Agenda Item: Construction Traffic and Access

From [REDACTED], Gt Staughton Parish Council [REDACTED]

© Crown copyright and database rights 2025.
Ordnance Survey AC0000808122

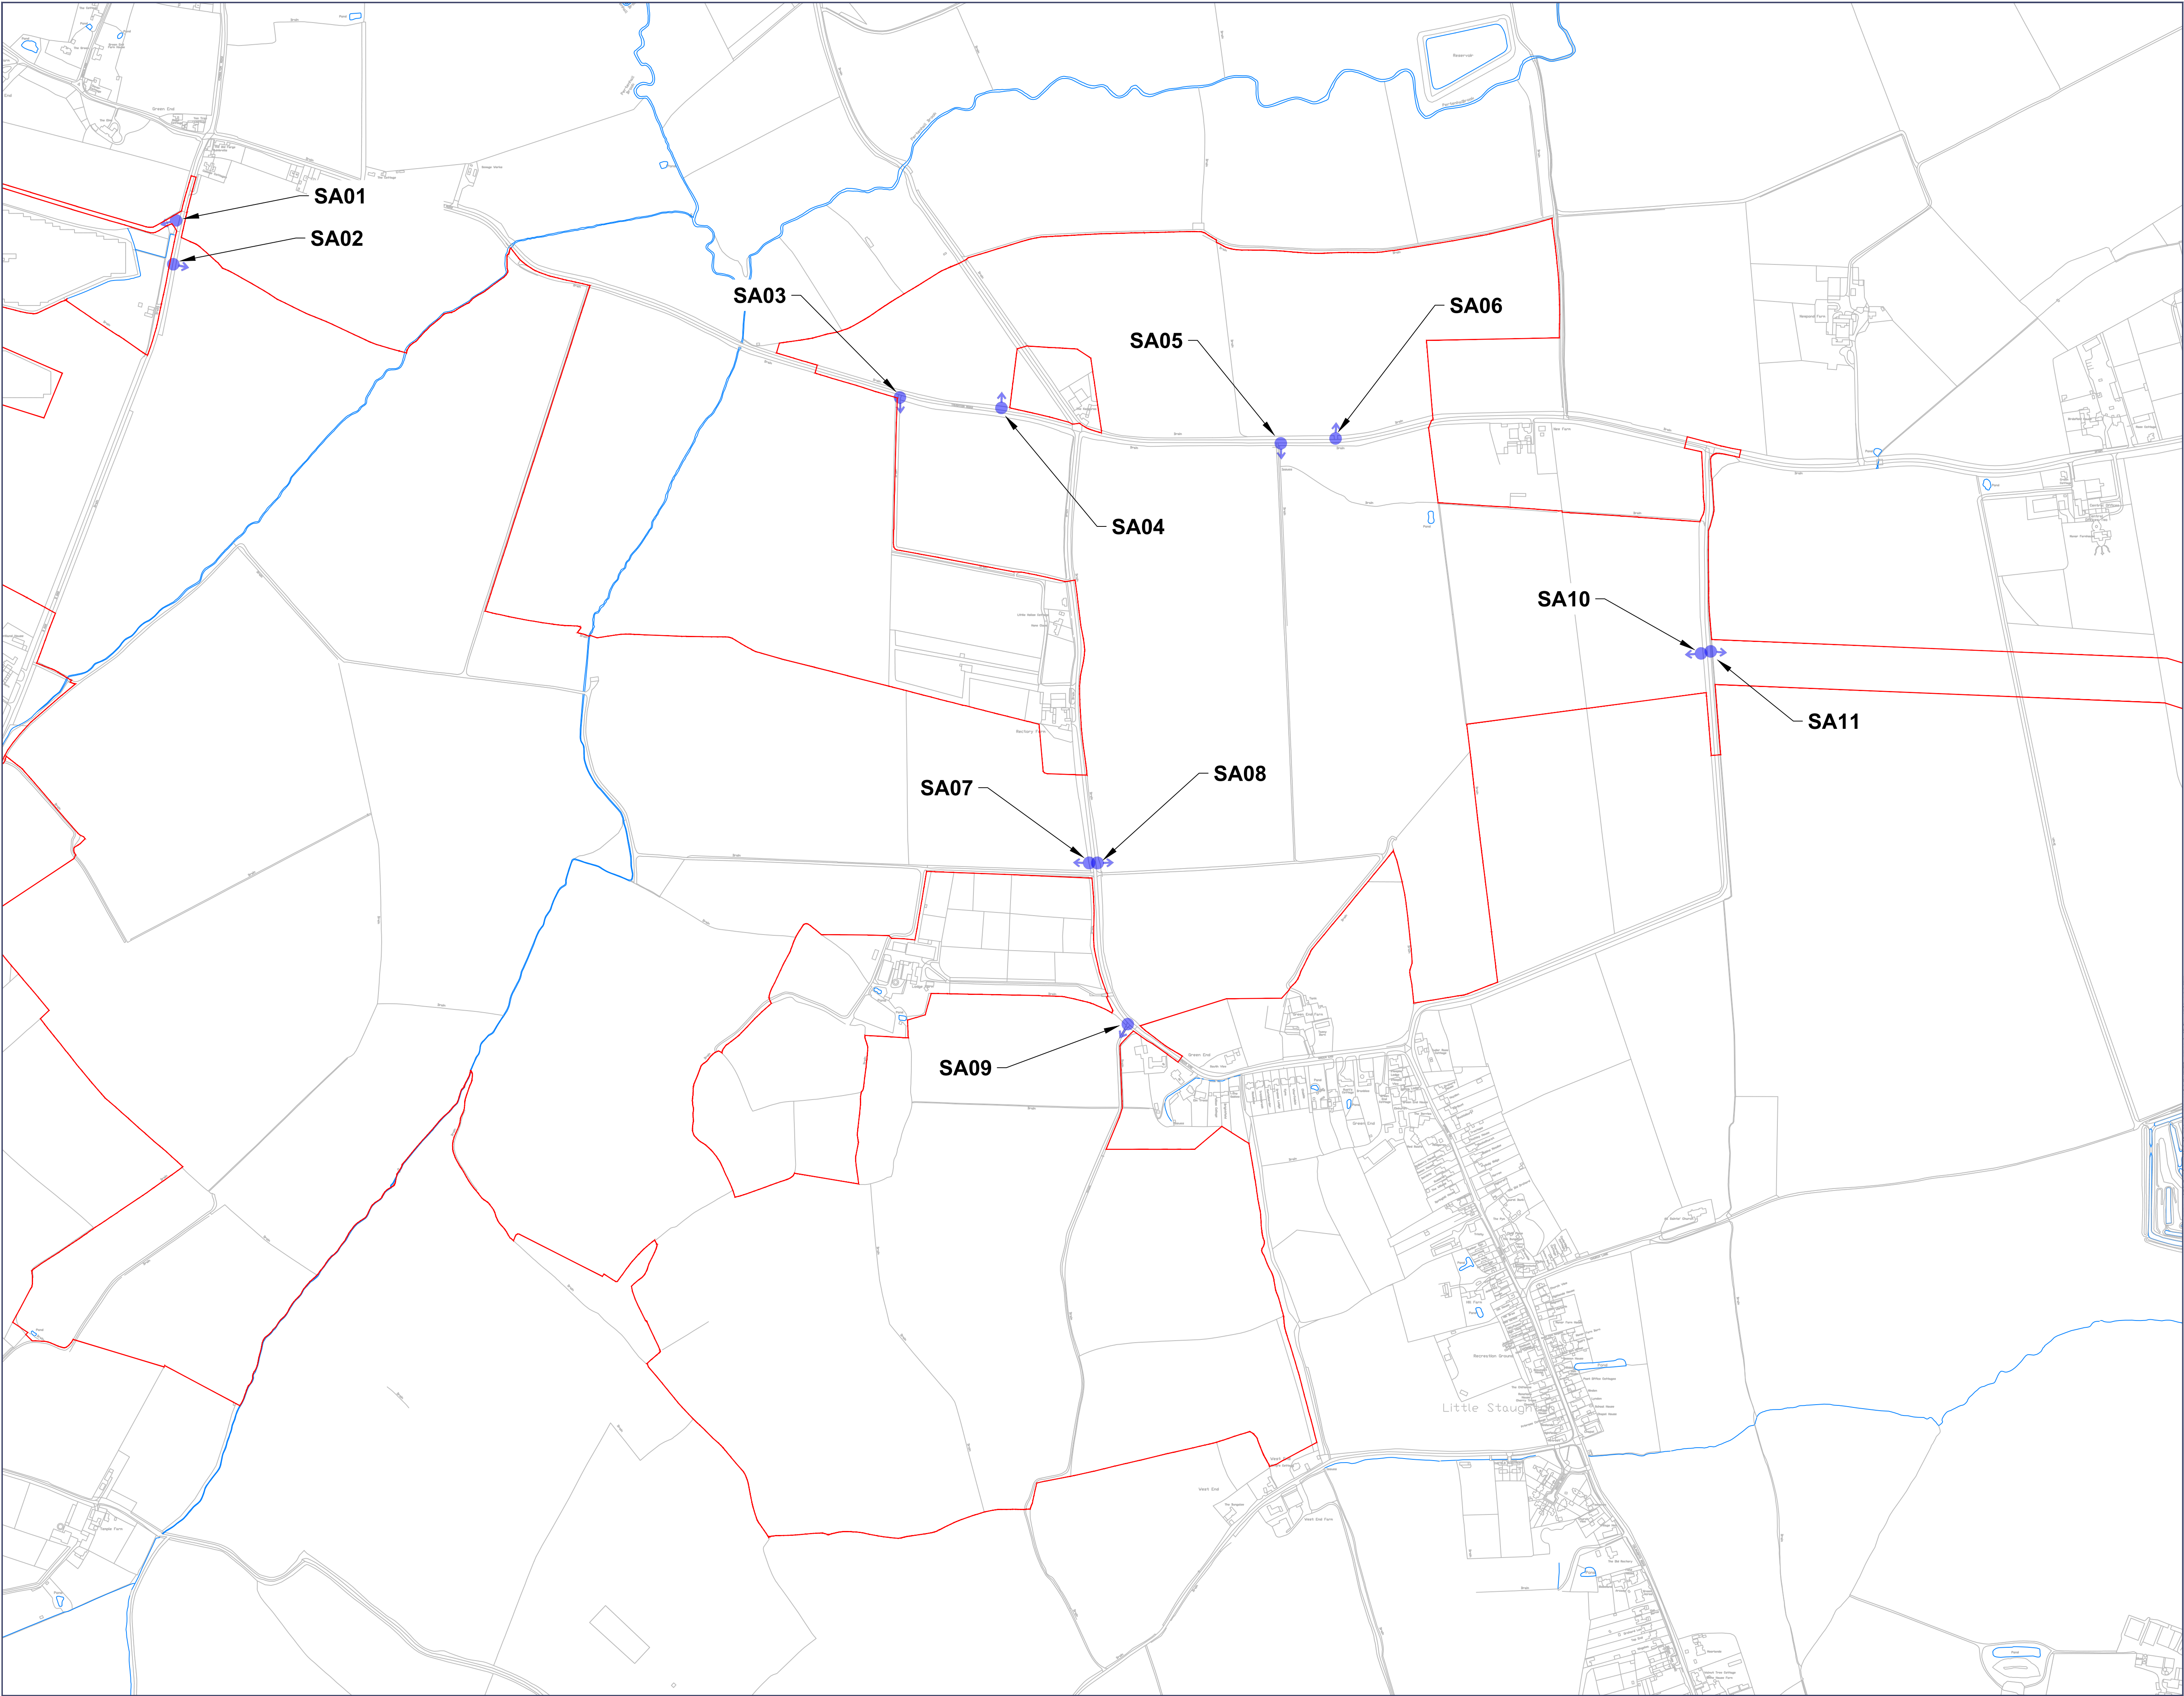
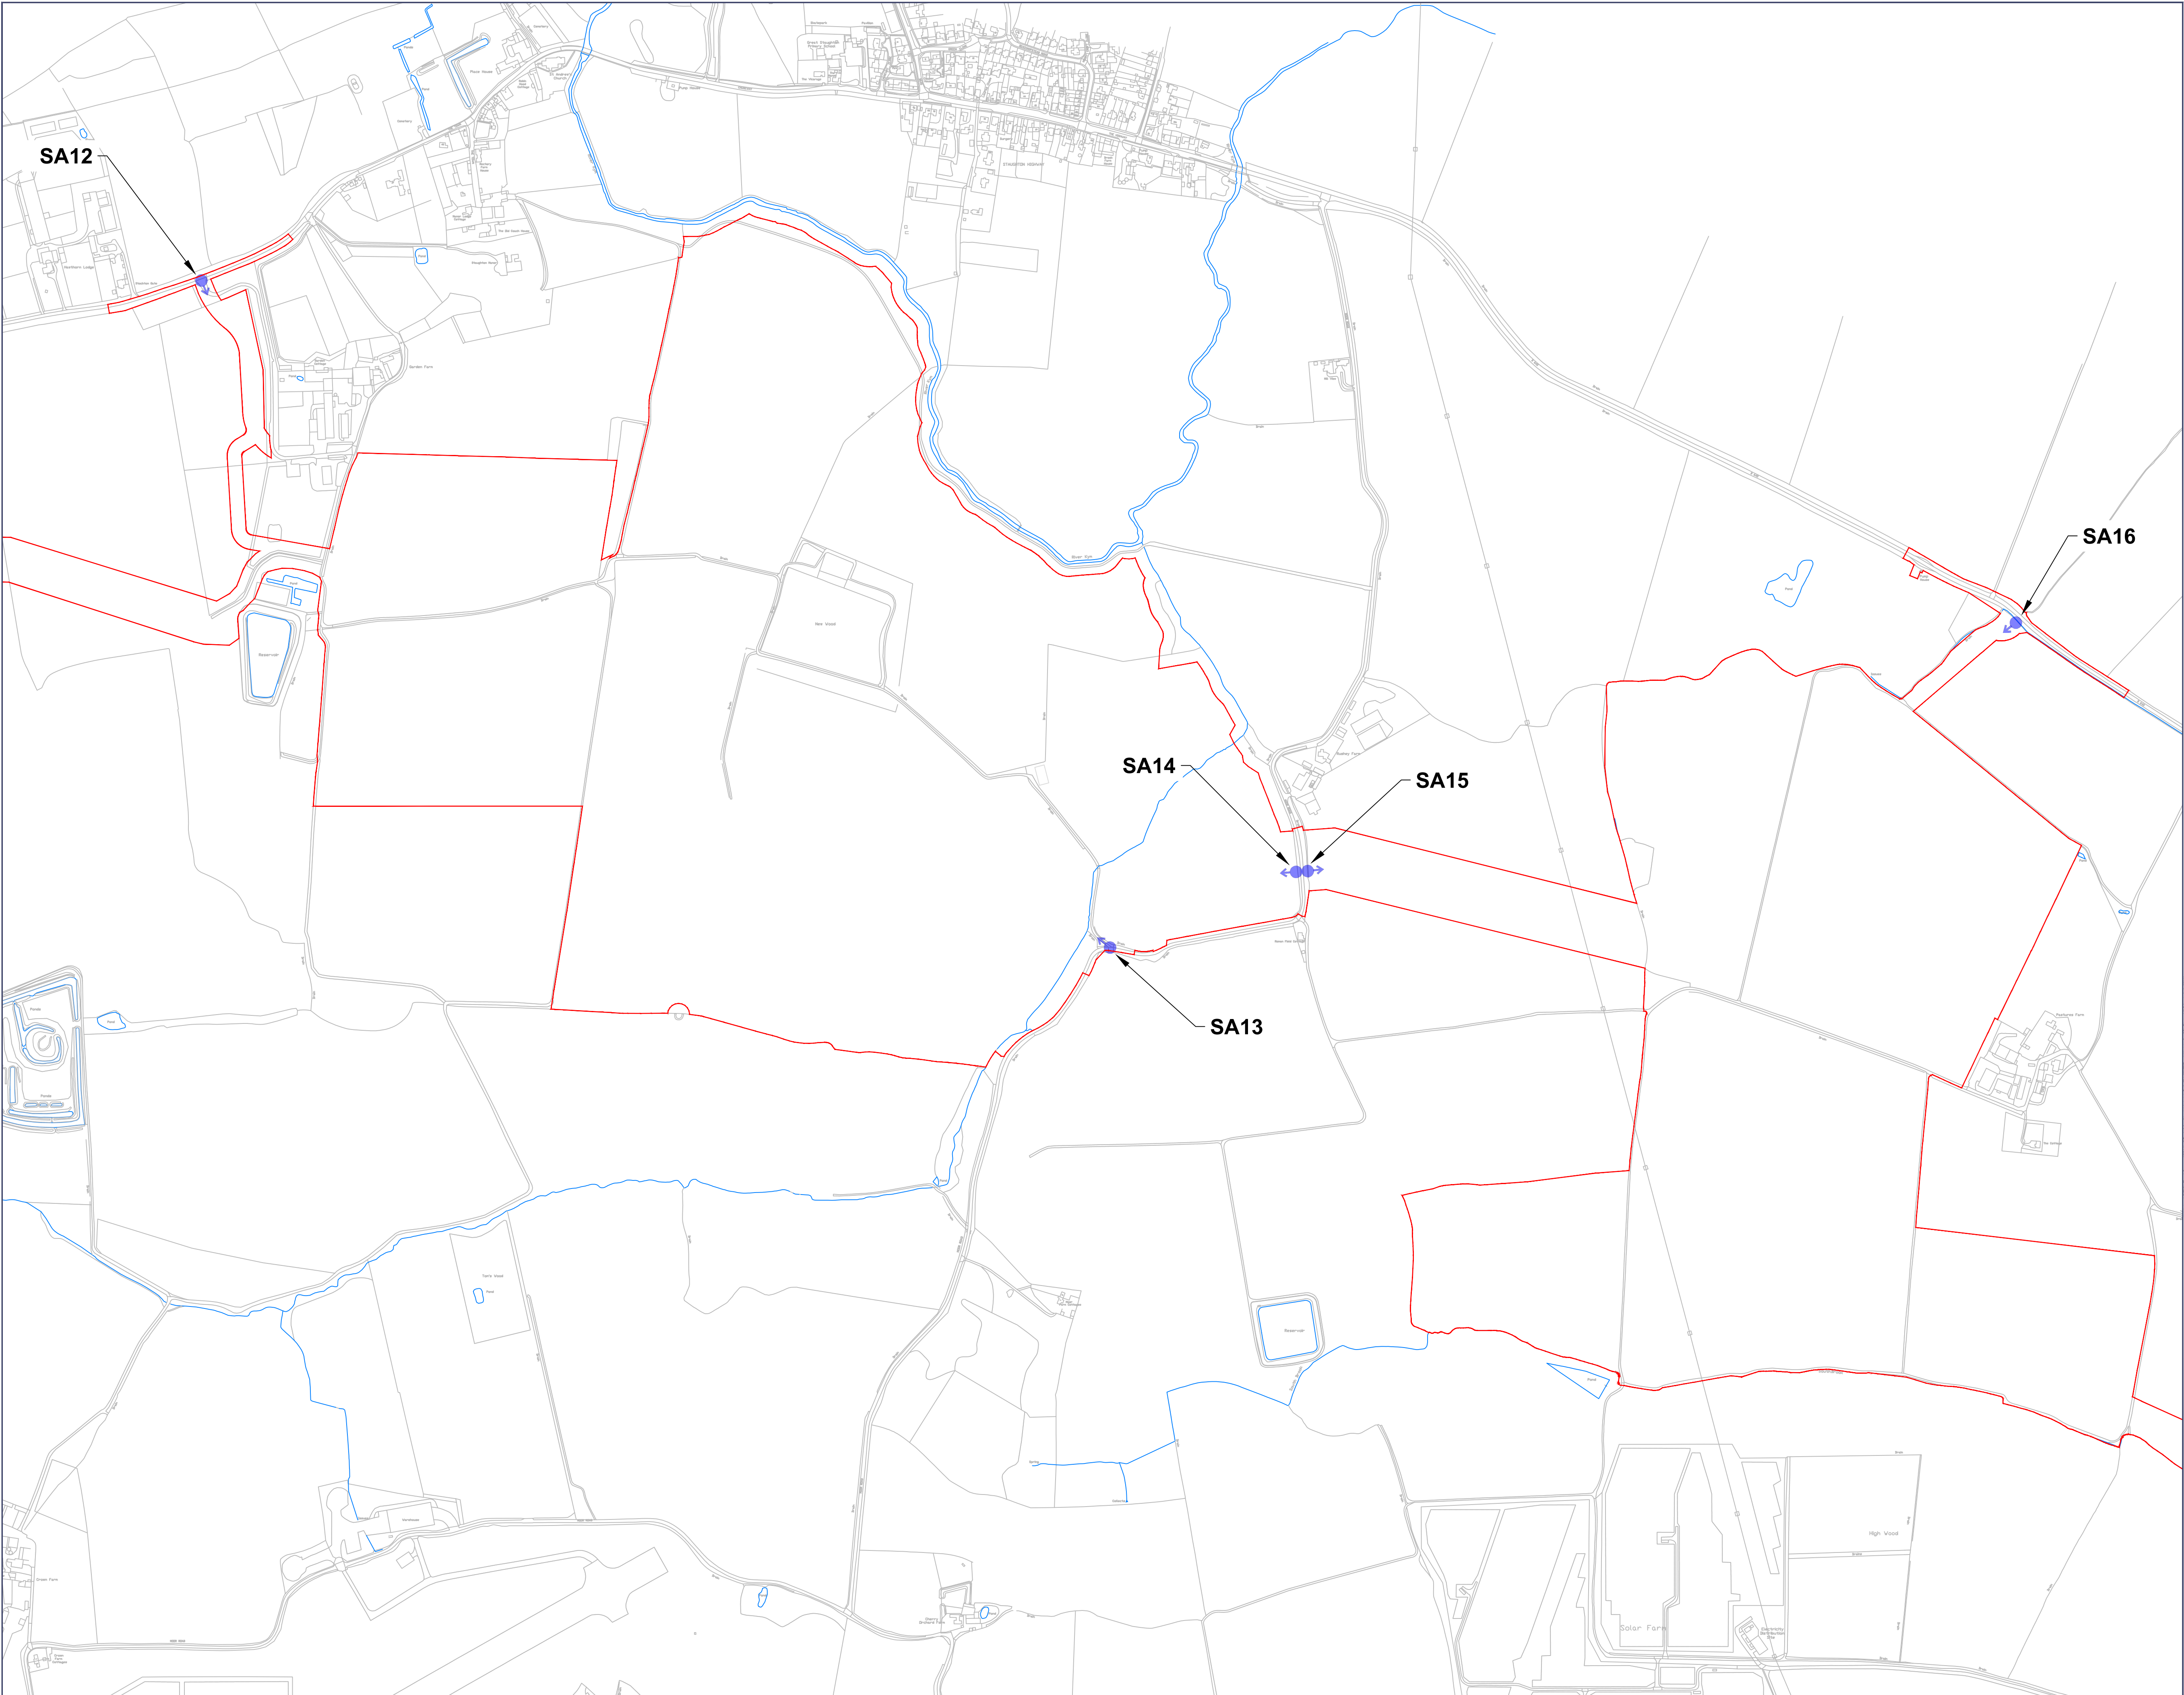
We understand that Brockwell's intention is for all the site traffic to come from the A1 along the B645 and enter the point at SA16. However, we would like to see a commitment that this will be strictly enforced otherwise we suspect that construction traffic including HGVs will be tempted to take the shortcut from SA12 back through the village in a way that would be exceedingly dangerous and disruptive:

B645 (MAIN ACCESS SA16 to site D). This stretch of road is considered locally to be extremely dangerous:

We are concerned that the project will cause obstruction on the B645 (especially around the main site D access SA16) which is the route to and from work school and shops for many parish residents. Any blockages, hold-ups or temporary traffic signals will come at a significant economic and social cost to local residents.
